# V1\_Traffic Impact Study\_comments.pdf Markup Summary

# TRAFFIC IMPACT STUDY

## ELK VIEW ESTATES

El Paso County, CO

FIGURE 1-2
SITE PLAN

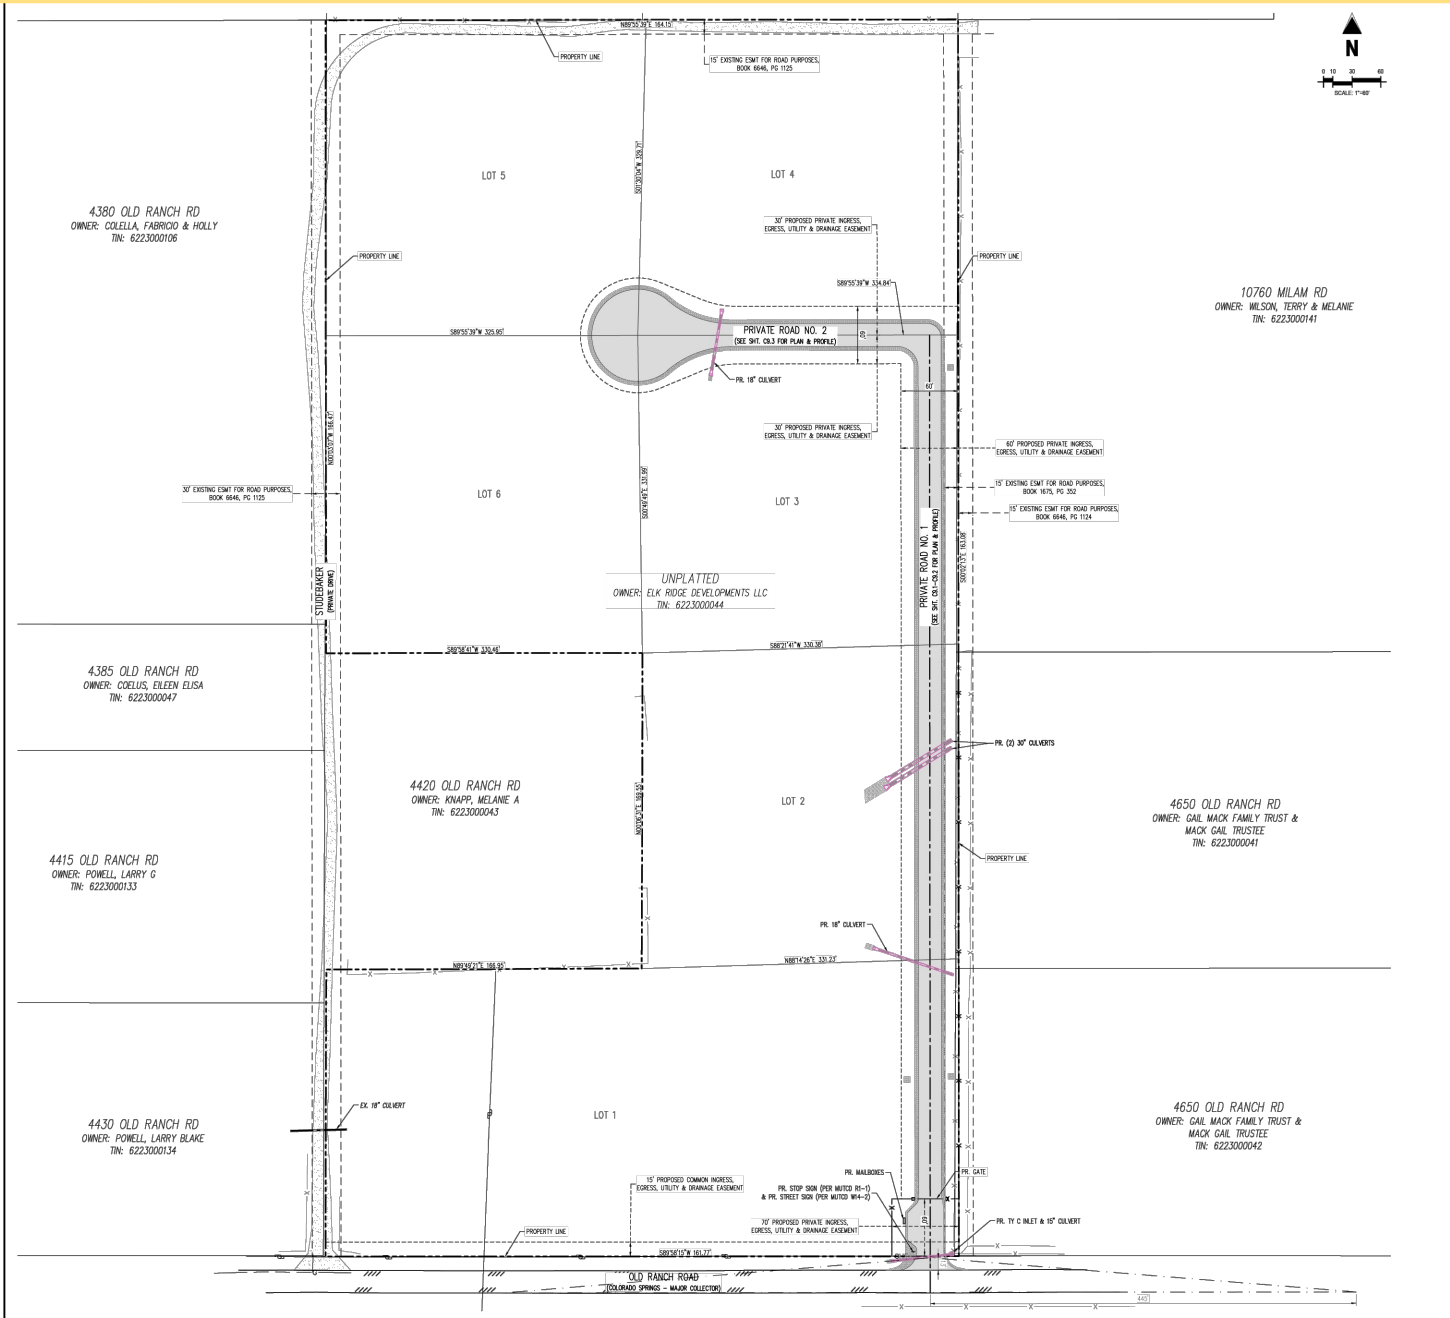
Did not see site distance triangles in Appendix A.  
Please provide

Site distance triangles  
provided in updated site  
plan of the updated TIS

FIGURE 4-2
SITE TRIPS

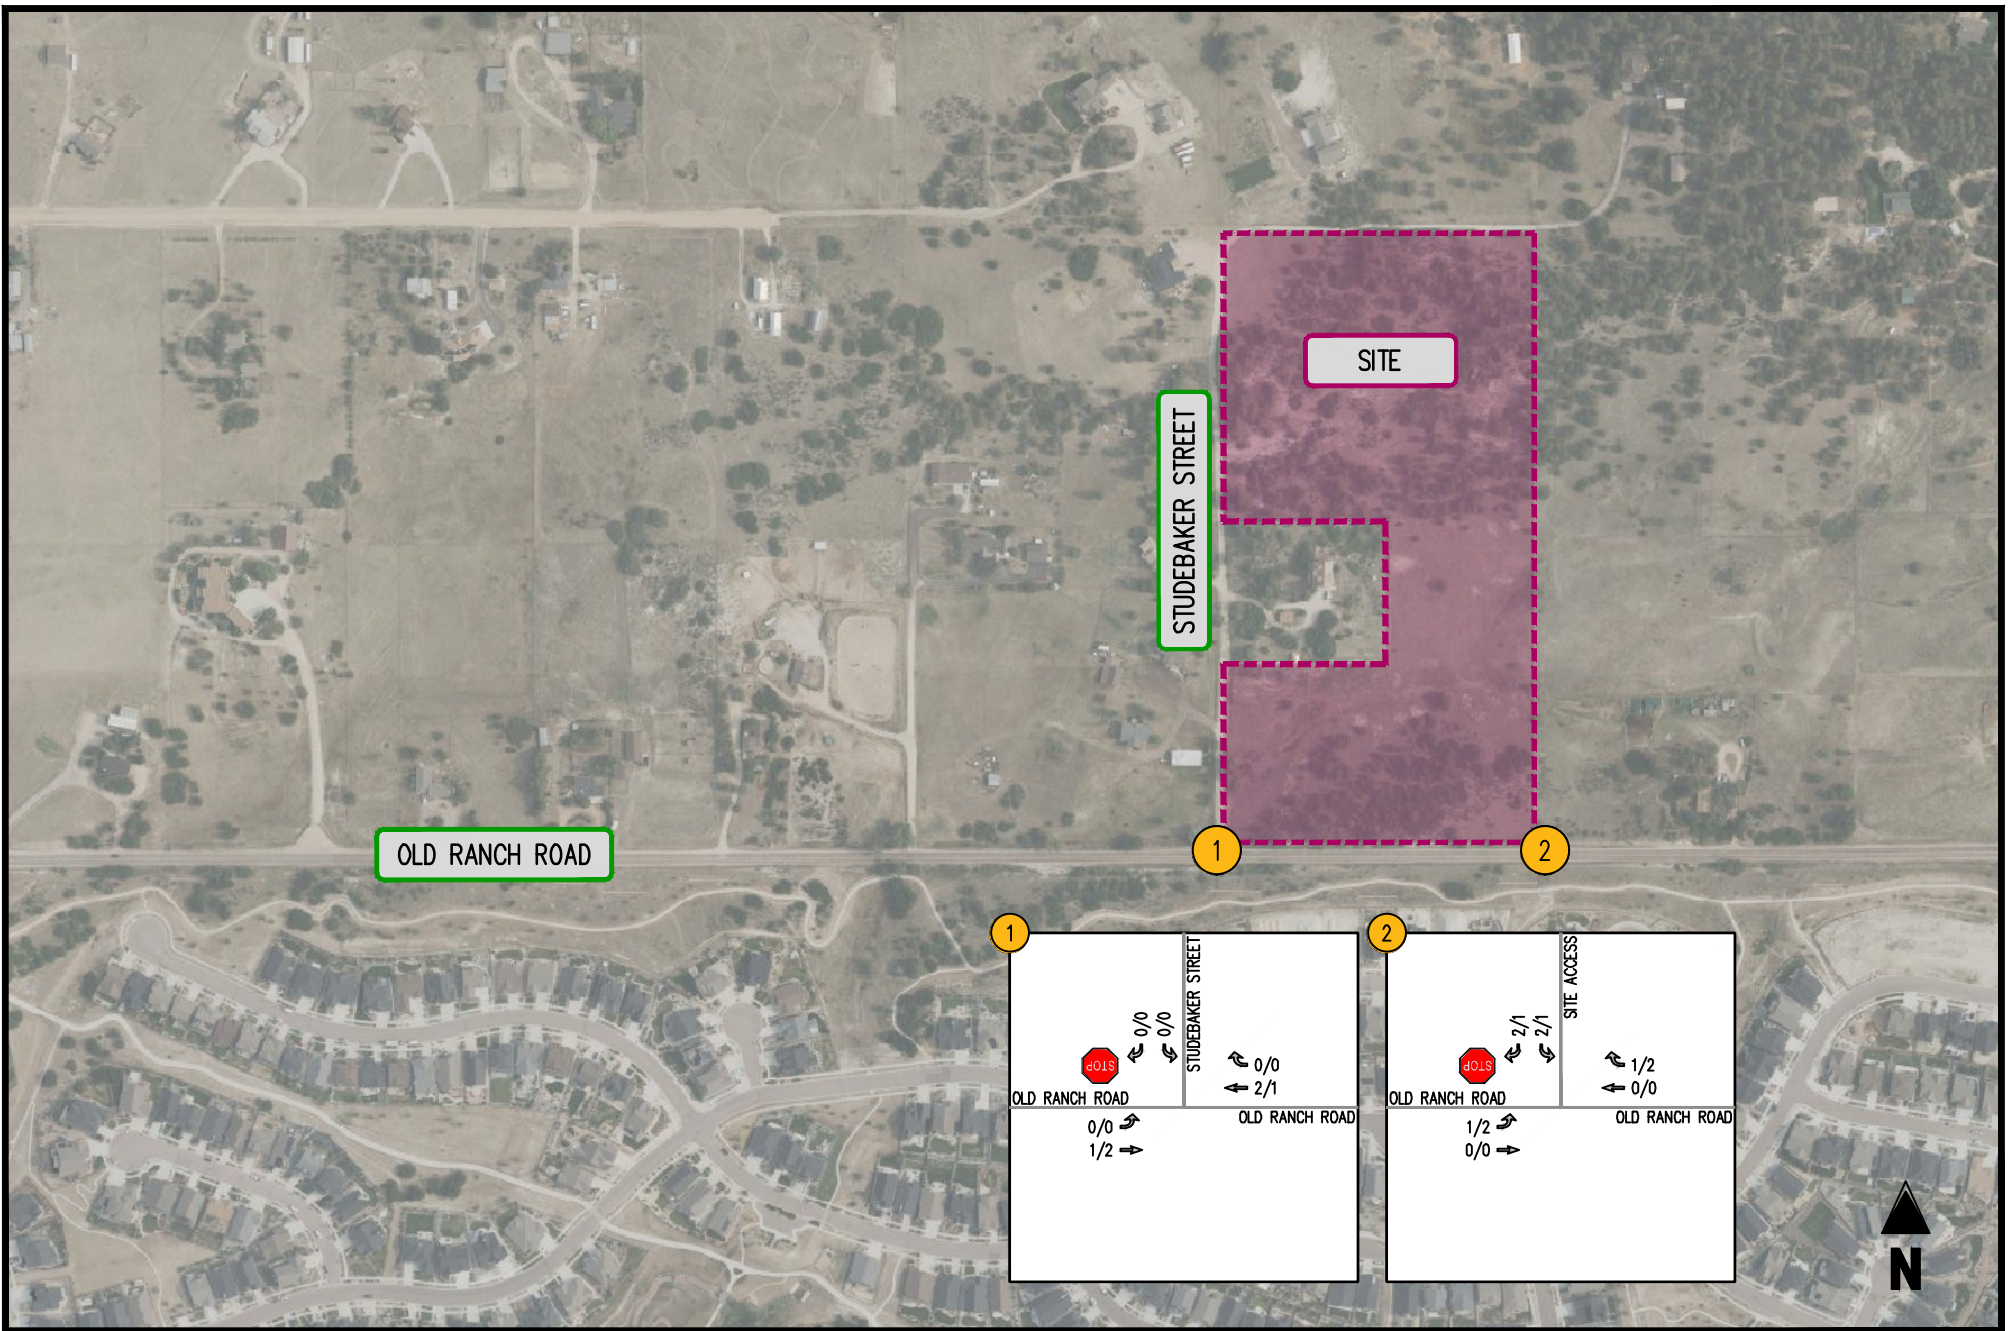
Please provide verification as this is the final land  
use application.

Verification provided  
in updated TIS
